CITY OF PORTLAND

July 8, 2002

RE: 152 Tucker Ave.
CBL: 330-B-015

An evaluation of your property at 152 Tucker Ave. on April 29 & July 2, 2002 revealed that the structure fails to comply with Section 421.10.1, (1 through 9), 1014.6.2, 1014.6.8, 1005.5, 1014.7, 1021, 1022 of the BOCA 1999 Code of the City of Portland.

①

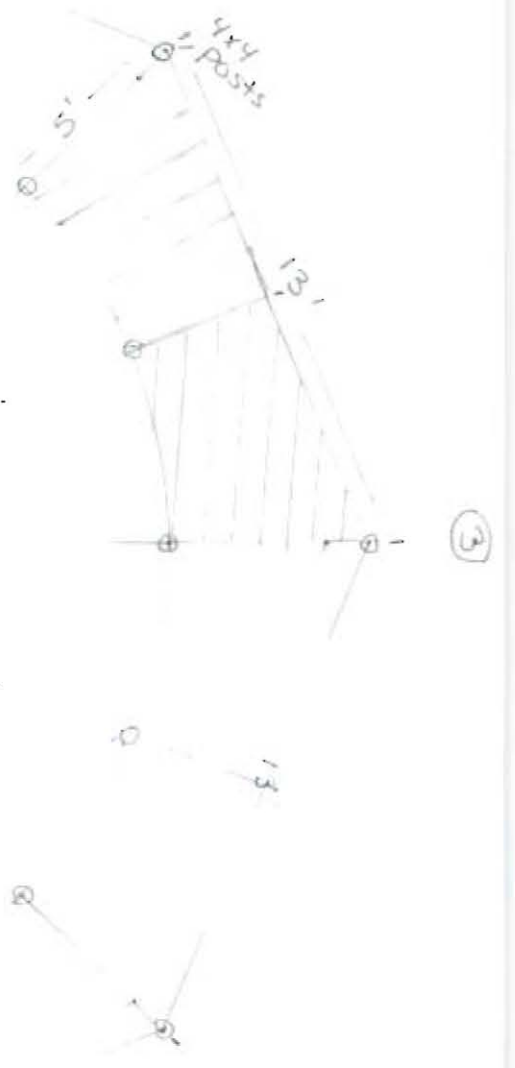
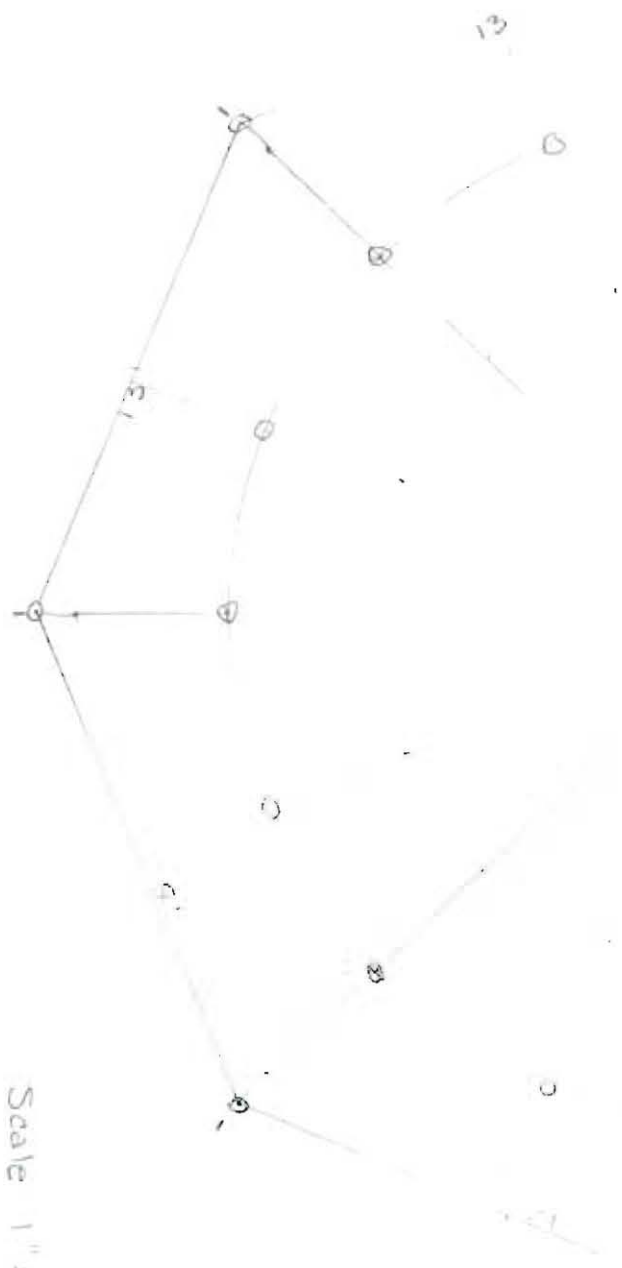
1. Barriers / Gates / Alarms to pool area are non-code compliant BOC 1999 Section 421.10.1 (1 through 9).
2. Deck Stair treads, nosings, risers & uniformity are non-code compliant (1999 BOCA Section 1014.6.8 and 1014.6.2).
3. Missing guardrails and handrail on stairs from upper to lower deck (1999 BOCA Sections 1005.5, 1014.7, 1021 and 1022.
